CITY OF ALBUQUERQUE

February 19, 2015

**Re: Assisted Living Home, 7500 Oakland Ave NE
Grading and Drainage Plan
Engineer's Stamp Date 2-2-15 (C19/D062)**

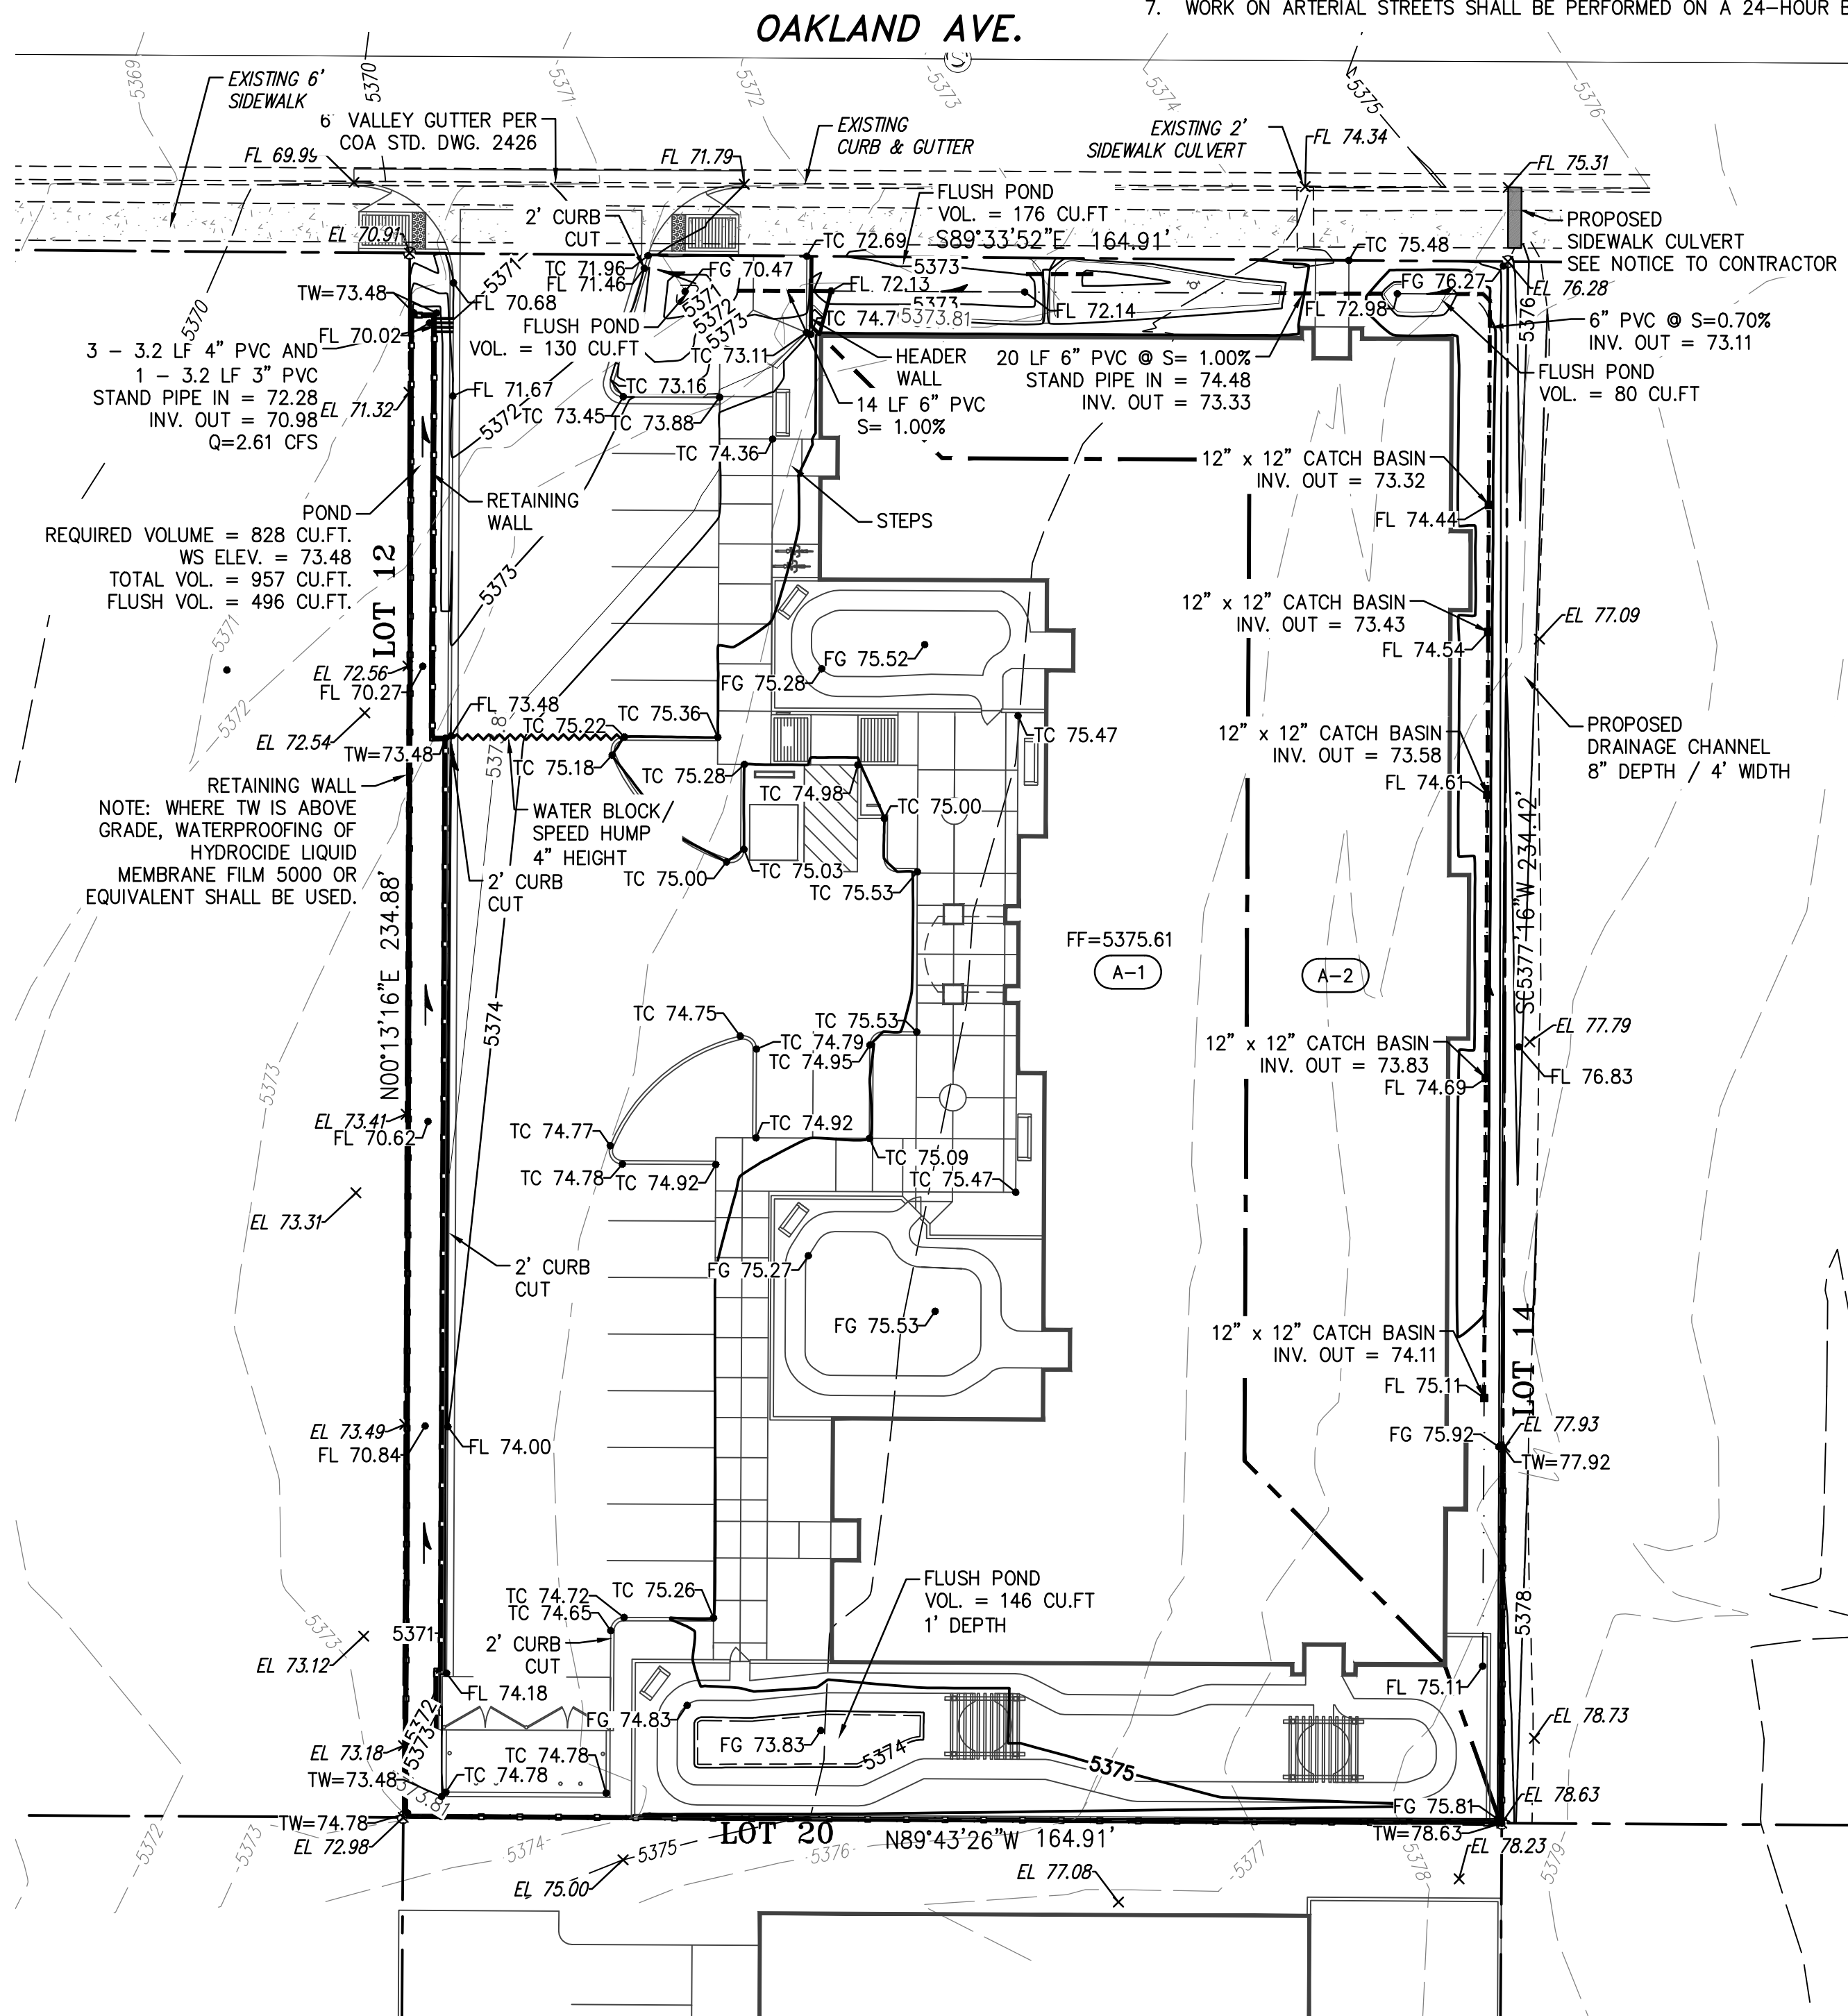
1. The application is to request SO-19 approval and provide the appropriate notes. A second copy of the plan is required as one copy goes to the DMD inspector.
2. Provide TW/BW grades for the retaining wall(s). Ensure a TW/BW is provided at the terminus of the retaining wall(s).
3. Provide Volume Required, Volume Provided and WSE for the detention pond. The Landscape Plan shows approximately 40 plants in this area. Therefore, the Volume Provided should be larger than the Volume Required by some factor.
4. Provide calculations for the sizing of the detention pond.
5. The monument sign is proposed in the flow line of the drainage swale along the northern part of the building. How is that going to work?
6. The 4" drain under the sidewalk along Oakland Ave seems undersized for 1.2 cfs.
